## Rezoning Petition Review – Charlotte Tree Ordinance

**Subject:** Urban Forestry Rezoning Petition Review Summary  
**To:** Charlotte Planning, Design & Development  
**From:** Tim Porter, Chief Urban Forester  
[Timothy.Porter@Charlottenc.gov](mailto:Timothy.Porter@Charlottenc.gov)  
 704-622-4829  
**Rezoning Petition:** 2021-118

Date	Description/Status
9/23/2021	UF 2 <sup>nd</sup> review, Tim Porter

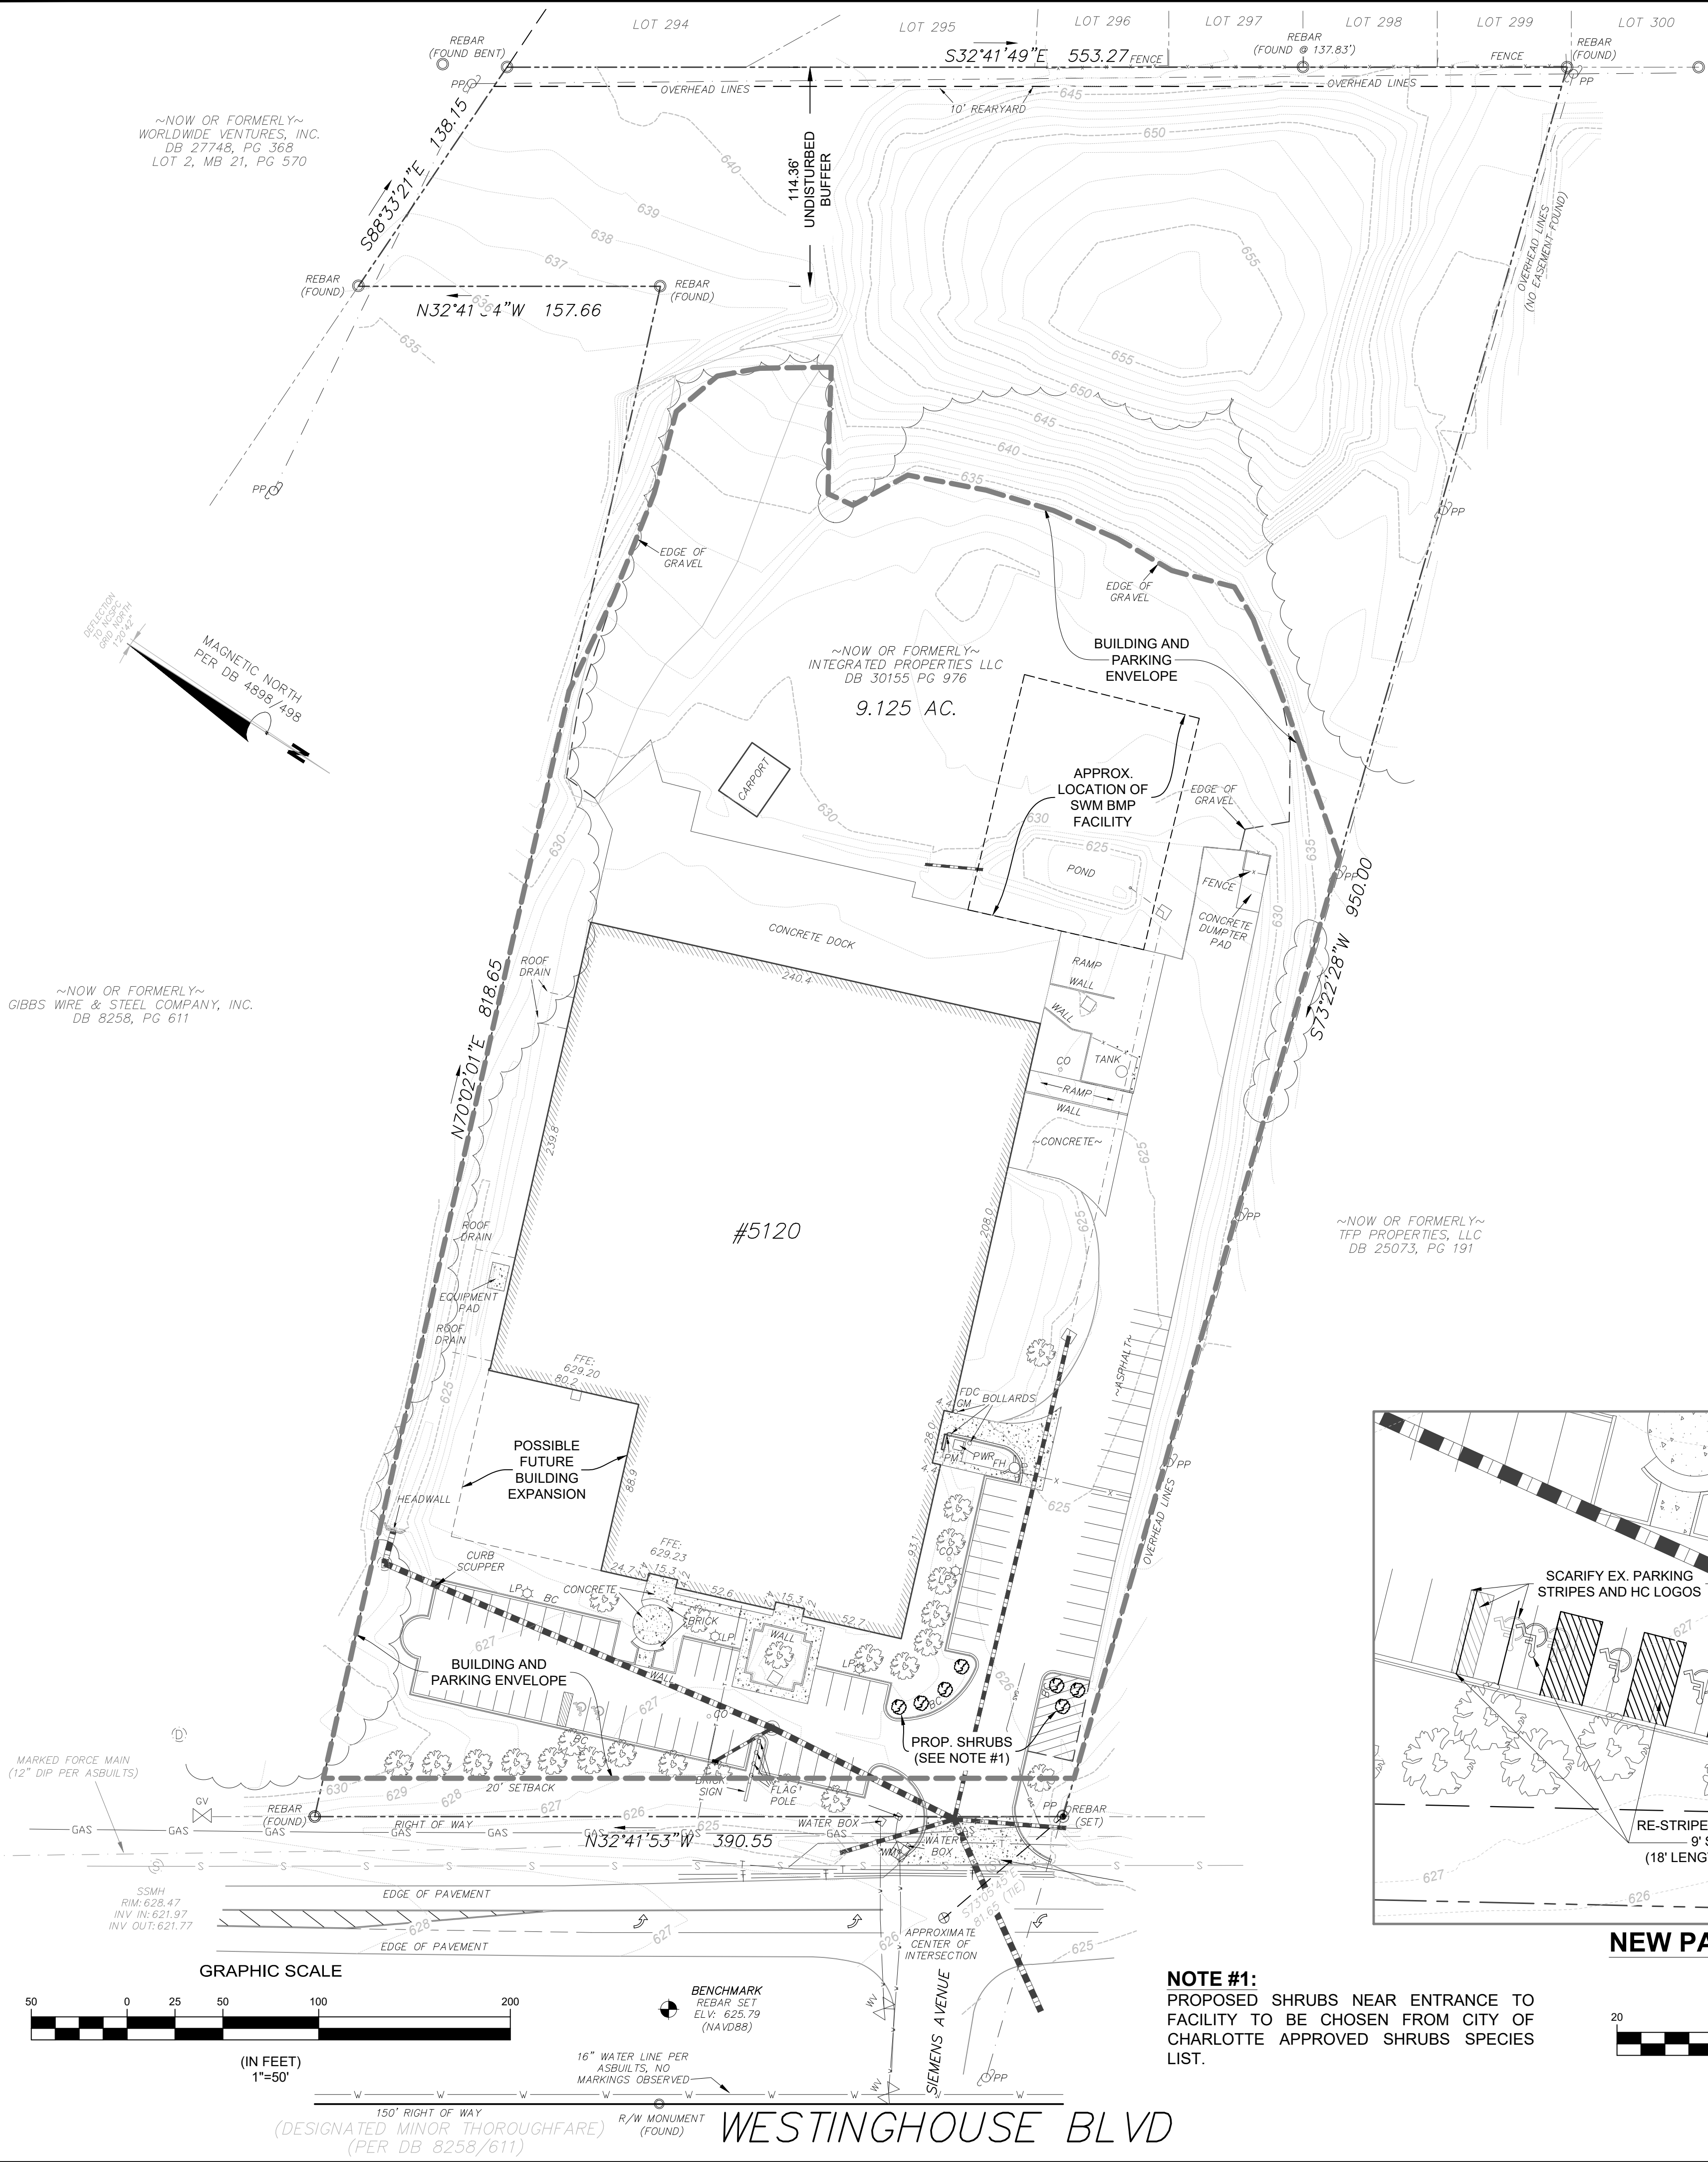
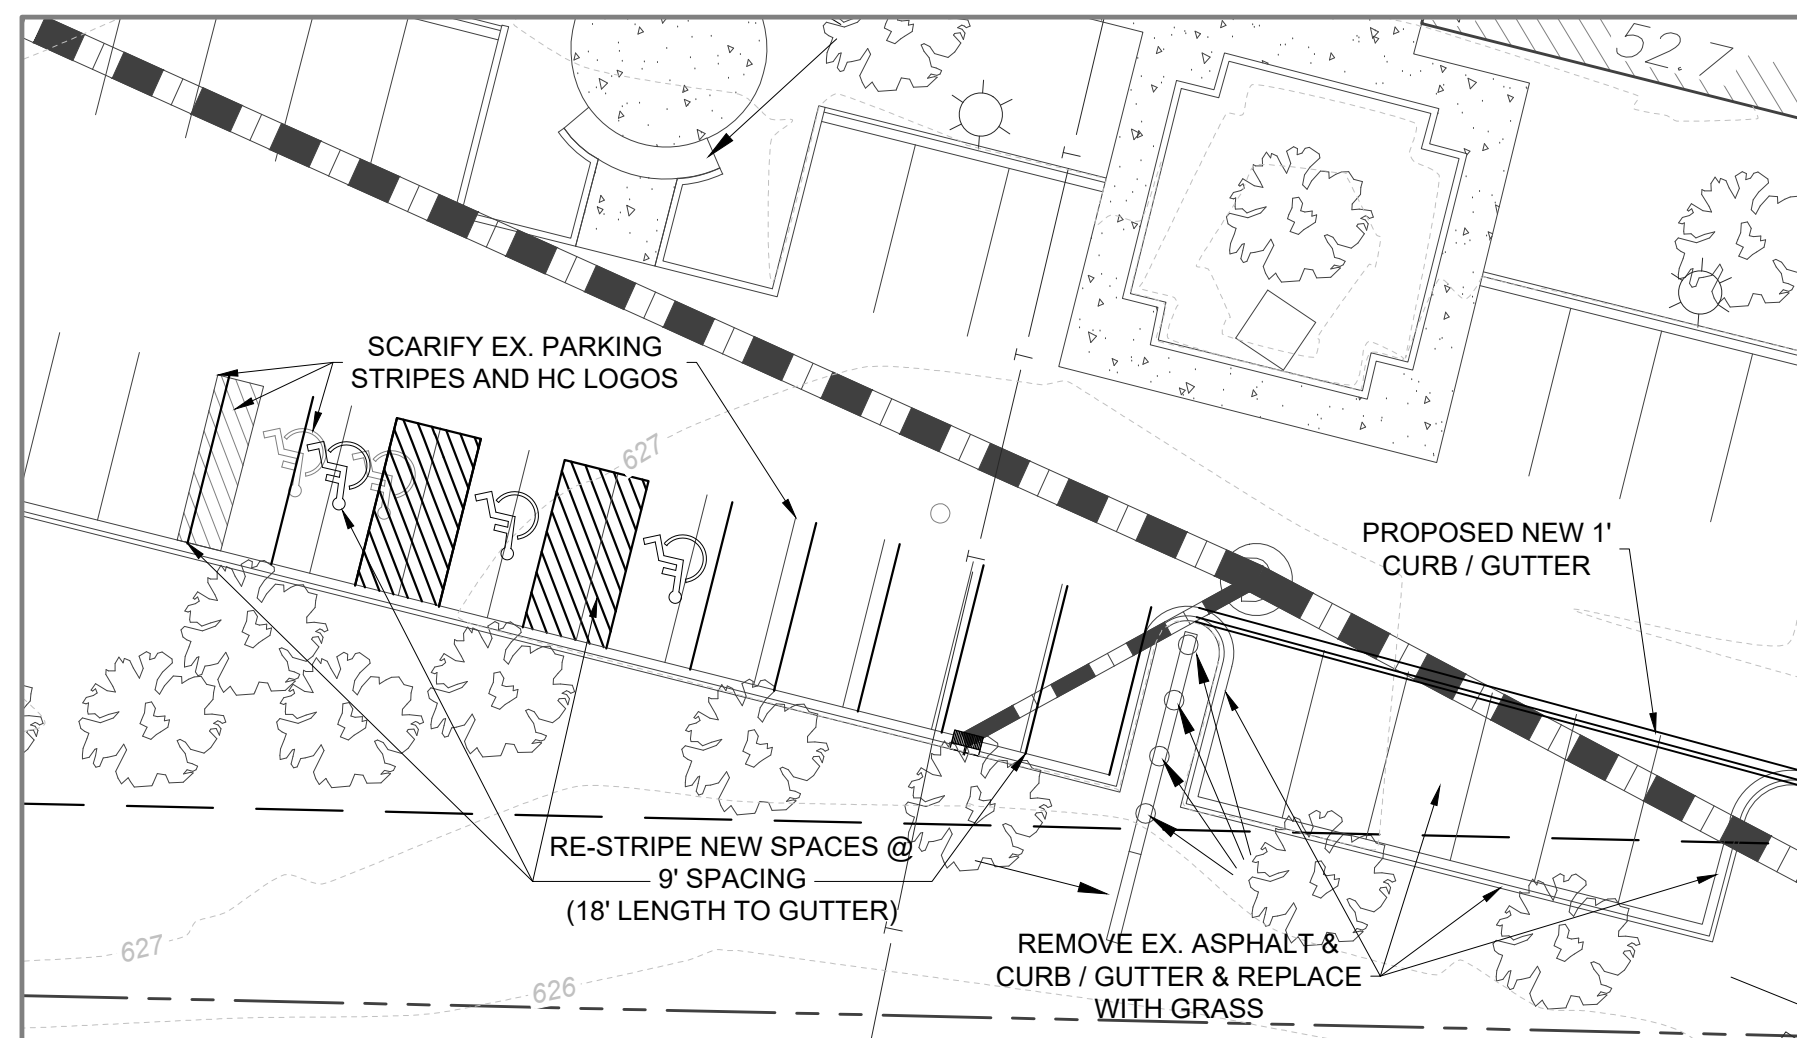
- Submit a tree survey per note 2. above.
- Include the following note: *“The site will comply with the Charlotte Tree Ordinance”*
